**WOODMEN HILLS METROPOLITAN DISTRICT
 REGIONAL WATER RECLAMATION FACILITY**
 NORTH/SOUTH BUILDING ELEVATIONS

Project No.:	112.88
Scale:	AS NOTED
Date:	05/22/17
Design:	RMM
Drawn:	RMM
Check:	JPM
Revised:

**SOUTH ELEVATION**  
 11x17 SCALE: 3/32"=1'-0"  
 24x36 SCALE: 3/16"=1'-0"

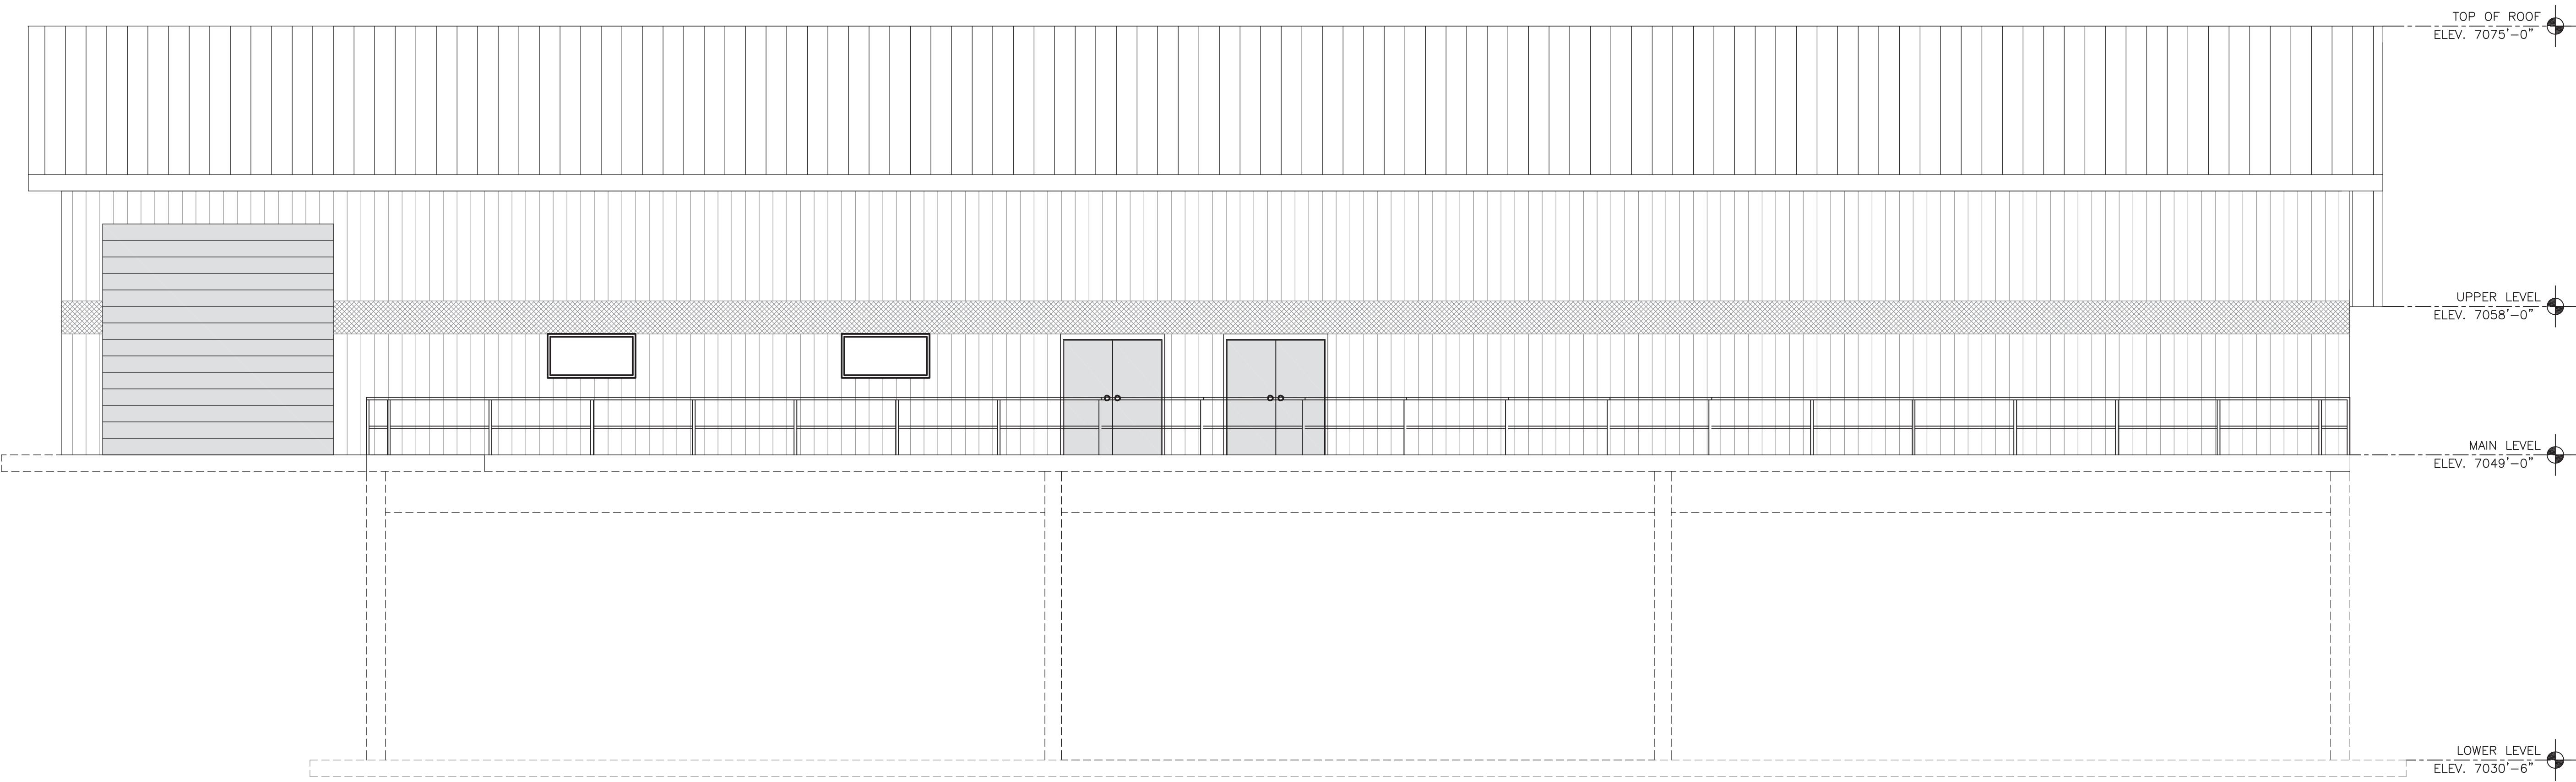
Revise the label to identify which face is the the south elevation.

**WOODMEN HILLS METROPOLITAN DISTRICT  
 REGIONAL WATER RECLAMATION FACILITY  
 NORTH/SOUTH BUILDING ELEVATIONS**  
 PCD FILE NO: PPR-17-027

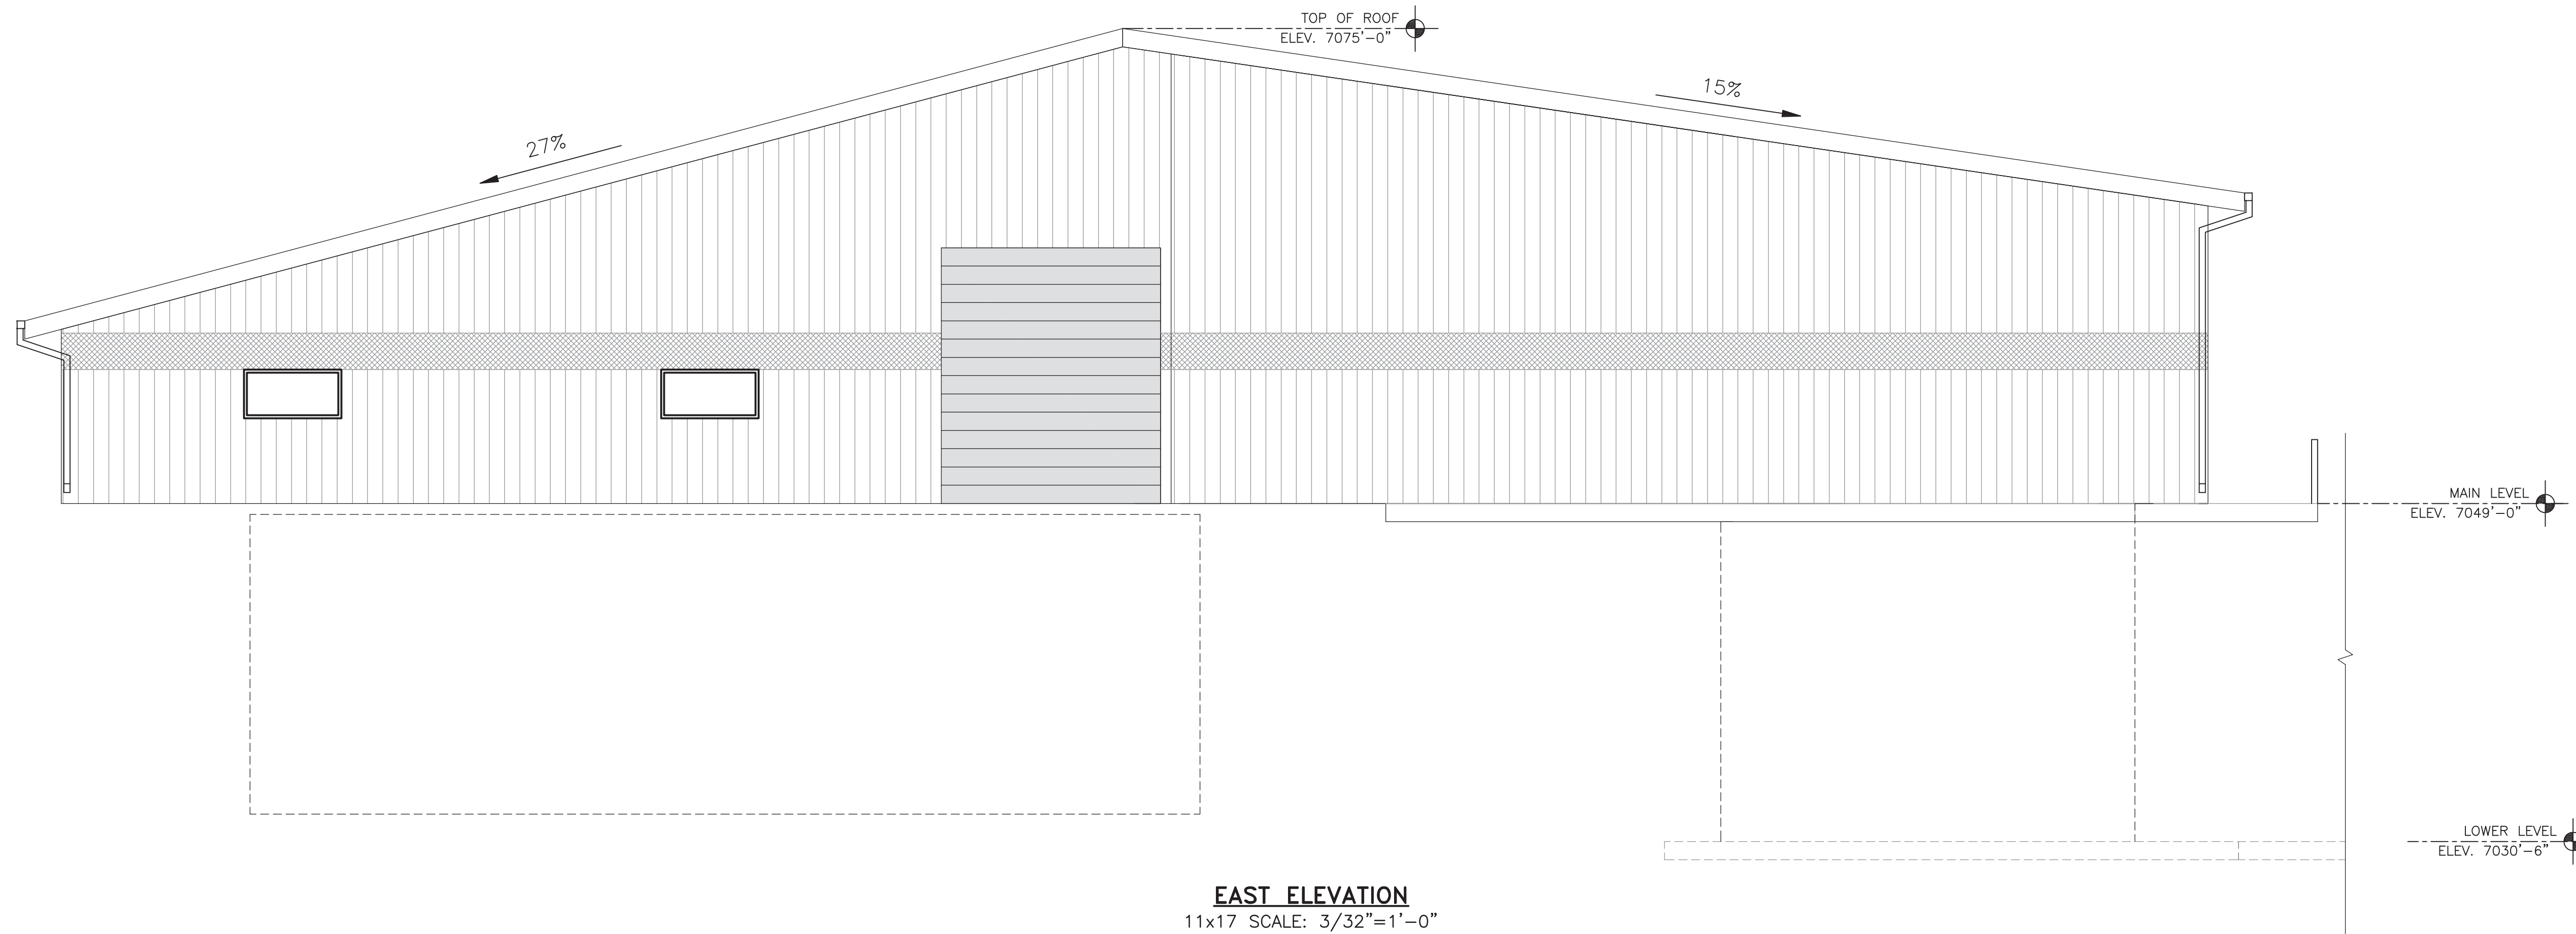
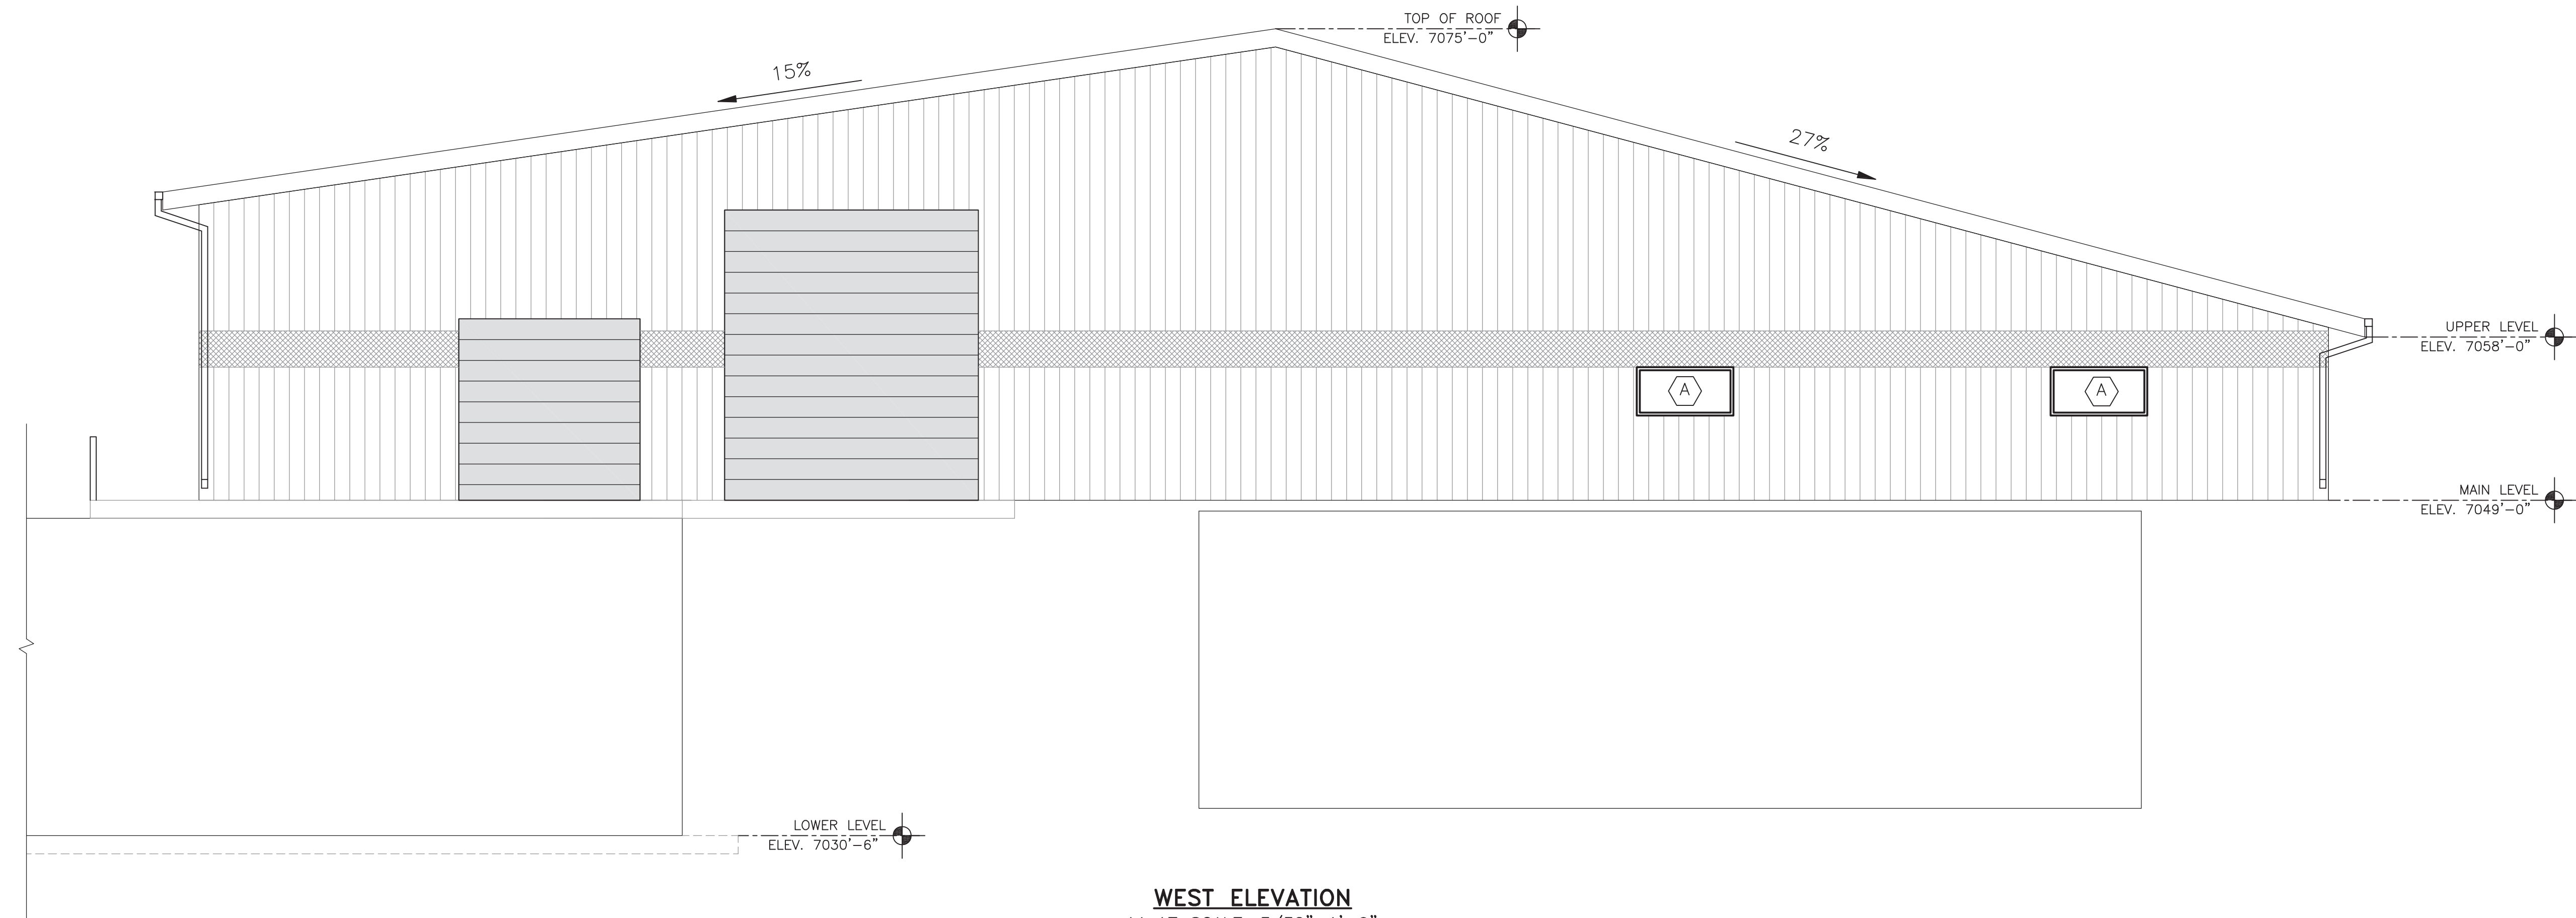
Add bar scale.
